From: [Brenda Larsen](#)
To: [Jeff Watson](#)
Subject: RE: SG-10-00019 State Parks
Date: Monday, November 29, 2010 4:18:09 PM

After conducting a review of the above named project, I have the following comments:

A Portion of the N 1/2 of Section 30, Township 17 North, Range 23 East, W.M.  
 Kittitas County Washington  
 Surveyed by LMH Date 11-09 Scale 1" = 500'  
 Drawn by Tml/MMH Date 11-09 Sheet 1 of 4  
 Checked by RNS Date 10-10 Project No. 09156

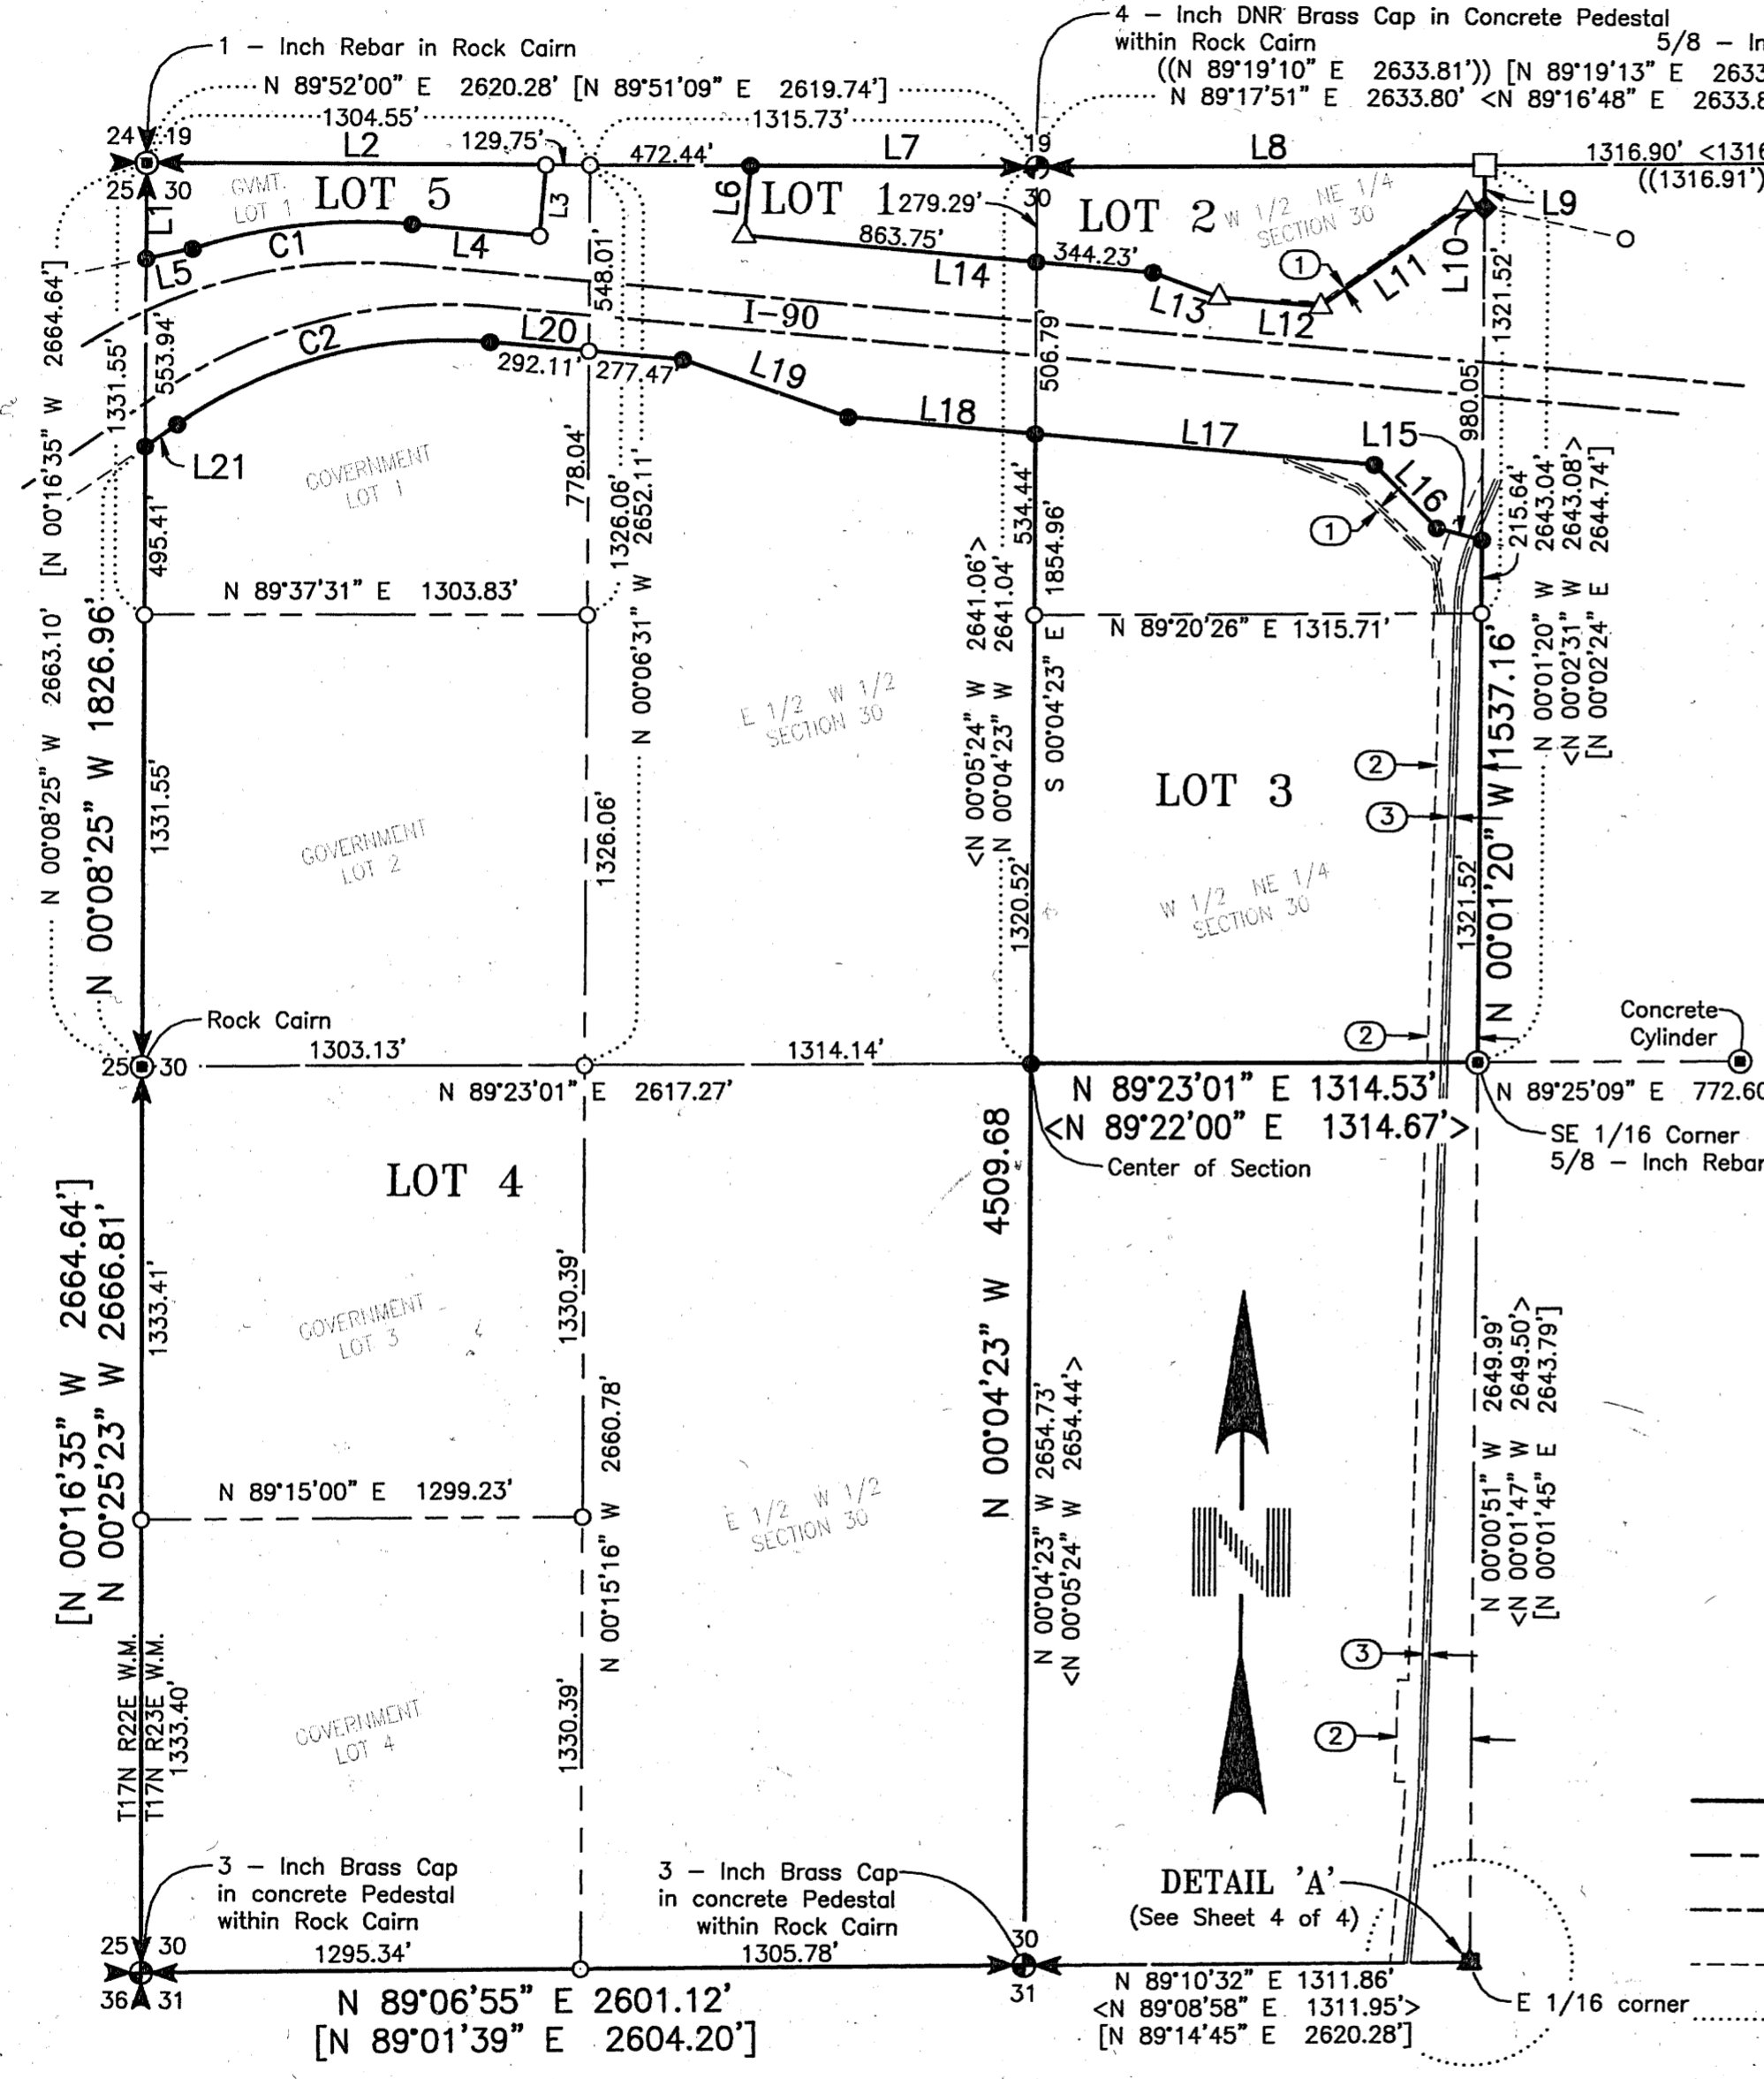
- Ensure that boundary line adjustments do not infringe upon existing structures, to include propane tanks, etc.
- Creation of any additional roads or access must comply with the International Fire Code.
- All future development must comply with the International Fire Code.
